**Planning Department
Transportation Development Services**

**Re: Dreamstyle Warehouse
1525 Renaissance Blvd NE
Traffic Circulation Layout
Engineer's/Architect's Stamp dated 5-12-15 (F16-D051A)**

SITE PLAN

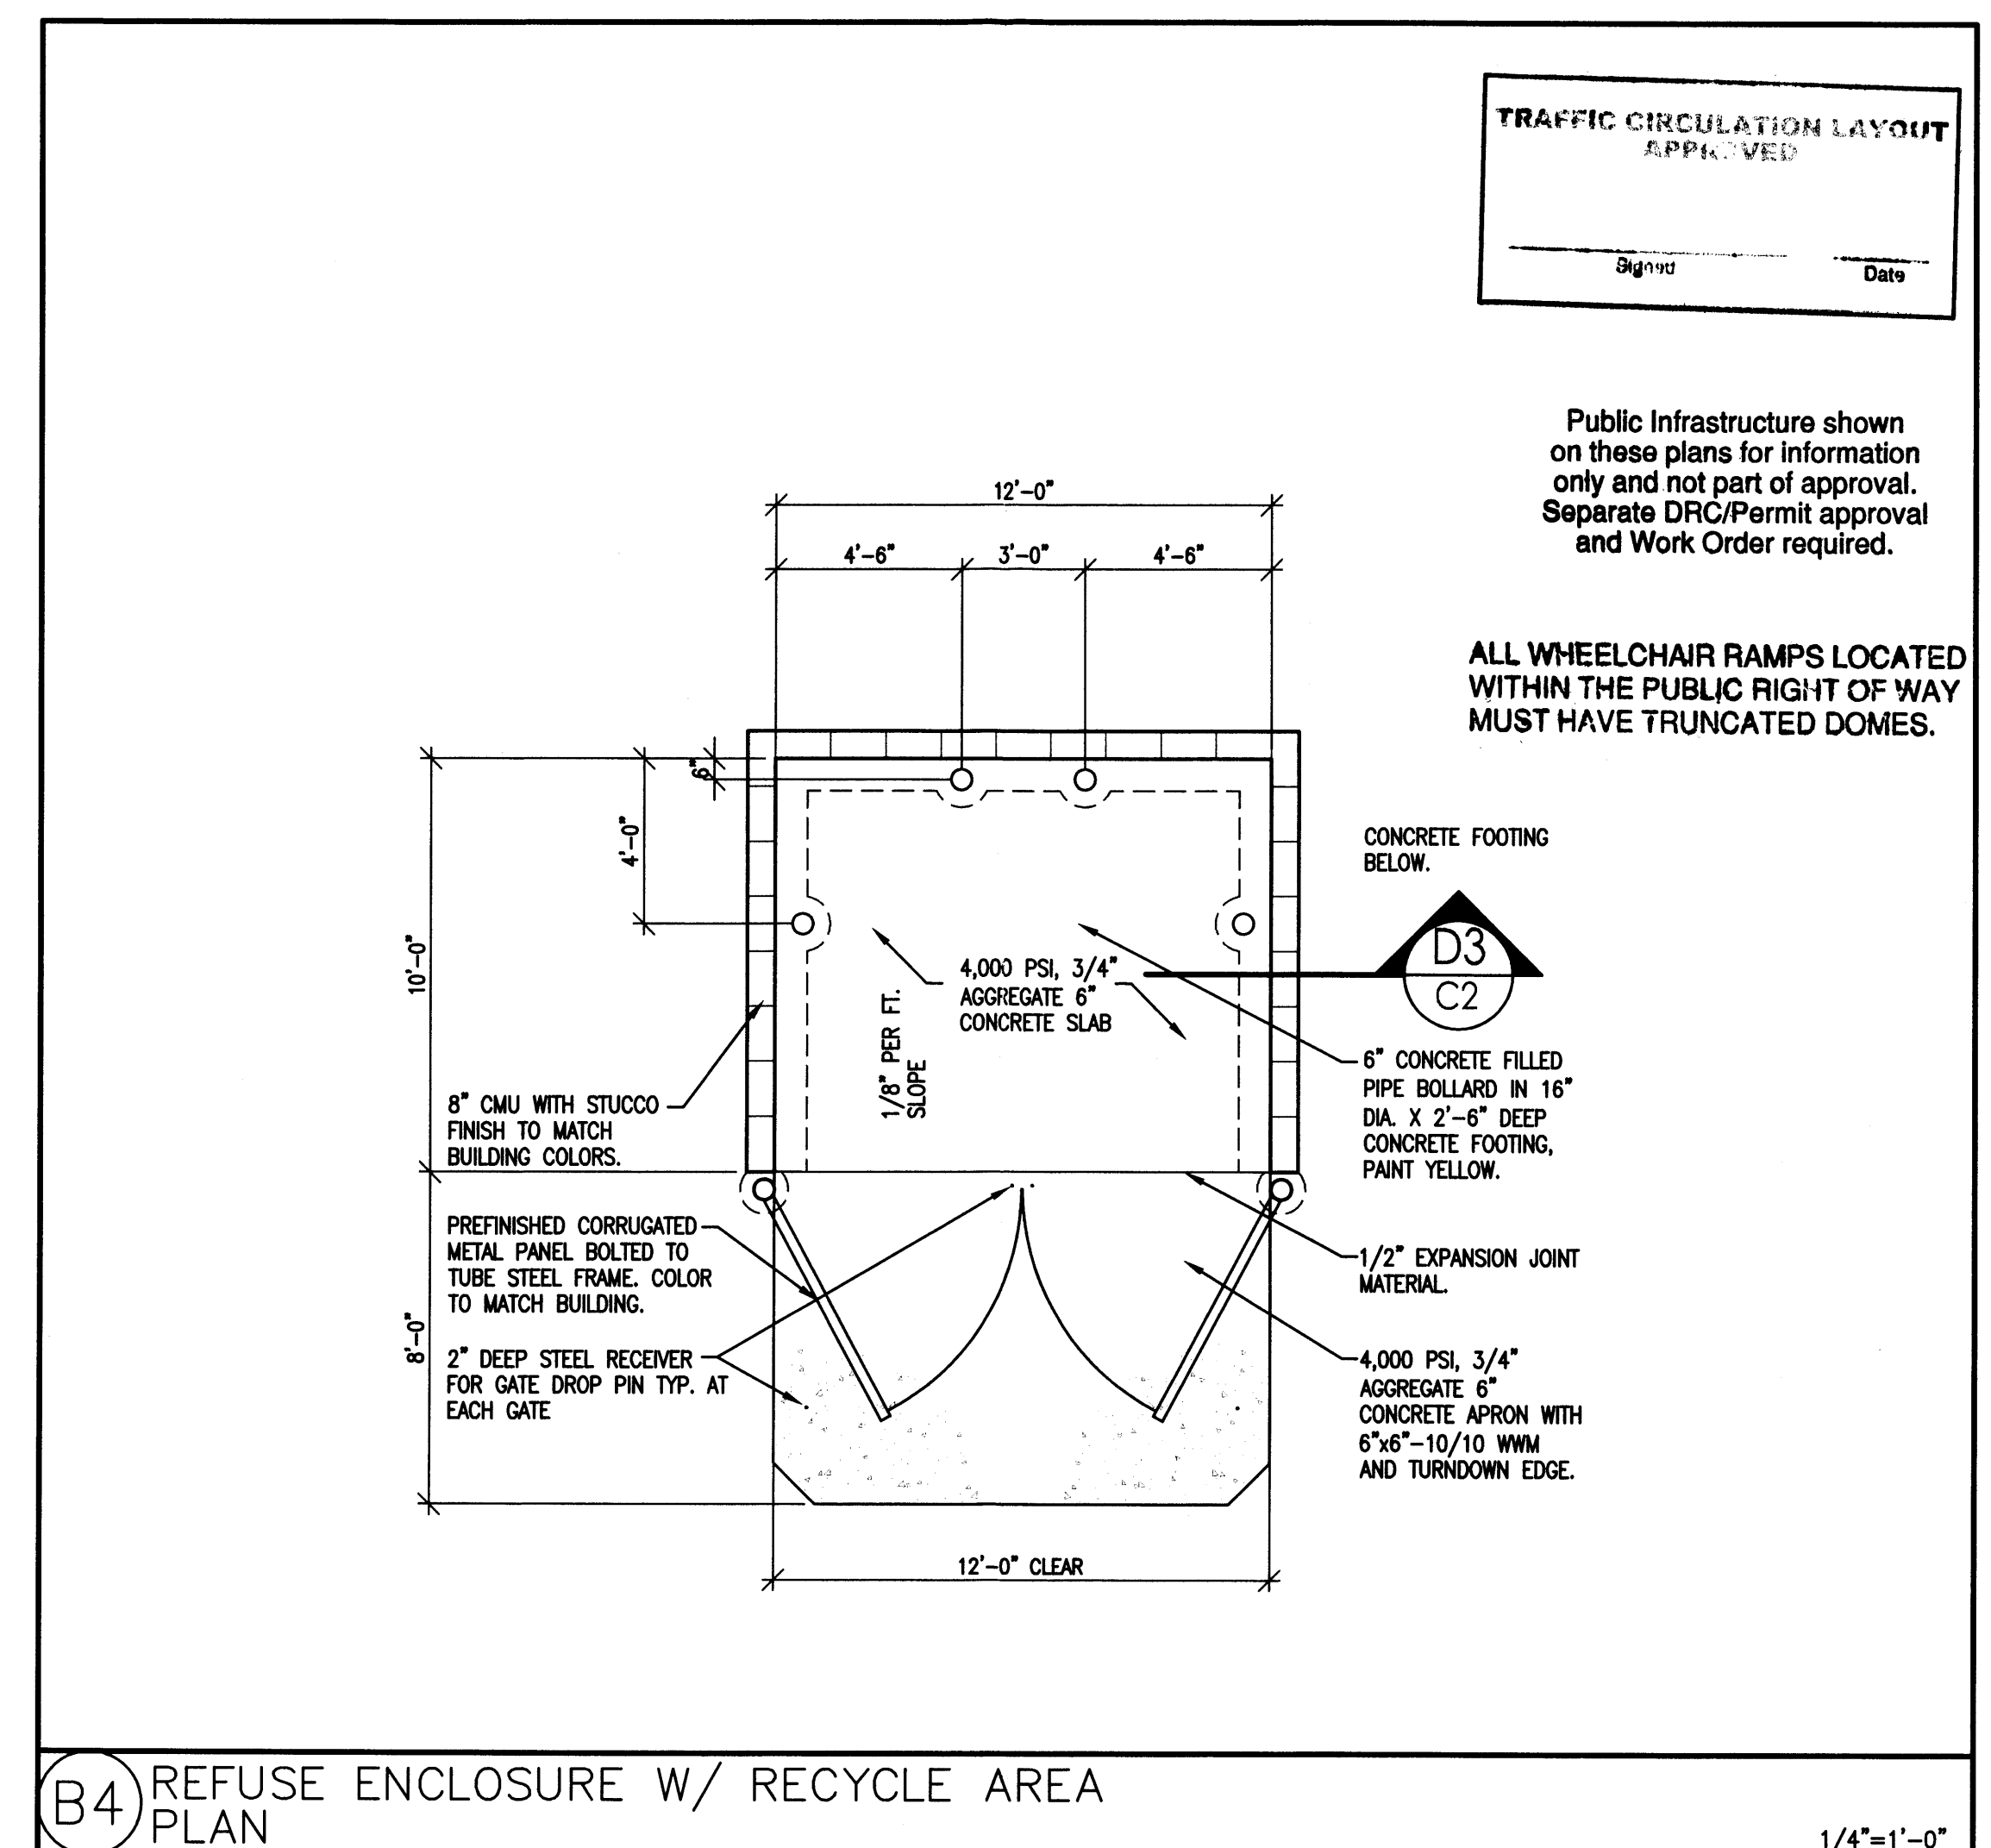
1. Identify and dimension the right of way width, medians, curb cuts and street widths on Renaissance Blvd.
2. Label the compact parking spaces by placing the words "**COMPACT**" on the pavement of each space. Only 30% of the required parking spaces are allowed to be compact designated, revise as necessary.

3. Please identify and detail the bicycle rack.
4. The handicap accessible spaces must be a minimum of 8.5 feet in width.
5. The handicap accessible spaces must include an 8-foot wide van access aisle; all other aisles should be 5 feet in width.

6. The ADA van accessible sign must have the required language per 66-7-352.4C NMSA 1978 "**Violators Are Subject to a Fine and/or Towing.**"
7. The ADA access aisle shall have the words "**NO PARKING**" in capital letters, each of which shall be at least one foot high and at least two inches wide, placed at the rear of the parking space so as to be close to where an adjacent vehicle's rear tire would be placed. (66-1-4.1.B NMSA 1978)

8. Please detail the Private Entrance off of Renaissance Blvd, per COA Standard Drawing No. 2426. Detail ADA ramps with truncated domes from public sidewalk to pedestrian walkway entrance to proposed building.

9. Per the DPM, a 6 ft. wide ADA accessible pedestrian pathway is required from the public sidewalk to the building entrances. Please clearly show this pathway and provide details of walkway and 6 ft. ADA landing at top of the ramp.
10. Design delivery vehicle route needs to be shown.
11. Service vehicle and/or refuse vehicle maneuvering must be contained on-site; provide a copy of refuse approval (if applicable). Detail Refuse truck route.
12. It is not apparent what type of pavement surface is being proposed. A hard driving surface will be required as part of this proposed project for parking area and drive aisles.
13. Please provide a sight distance exhibit for entrance from Renaissance Blvd. (see the *Development Process Manual, Chapter 23, Section 3, Part D.5 Intersection Sight Distance*).

14. Please add the following note to the clear sight triangle: "Landscaping and signage will not interfere with clear sight requirements. Therefore, signs, walls, trees, and shrubbery between 3 and 8 feet tall (as measured from the gutter pan) will not be acceptable in this area."
15. Provide the address of the proposed building on the Site Plan.
16. Please add the Vicinity Map and Zone Atlas Map number on the Site Plan itself.
17. Please include two copies of the traffic circulation layout at the next submittal.
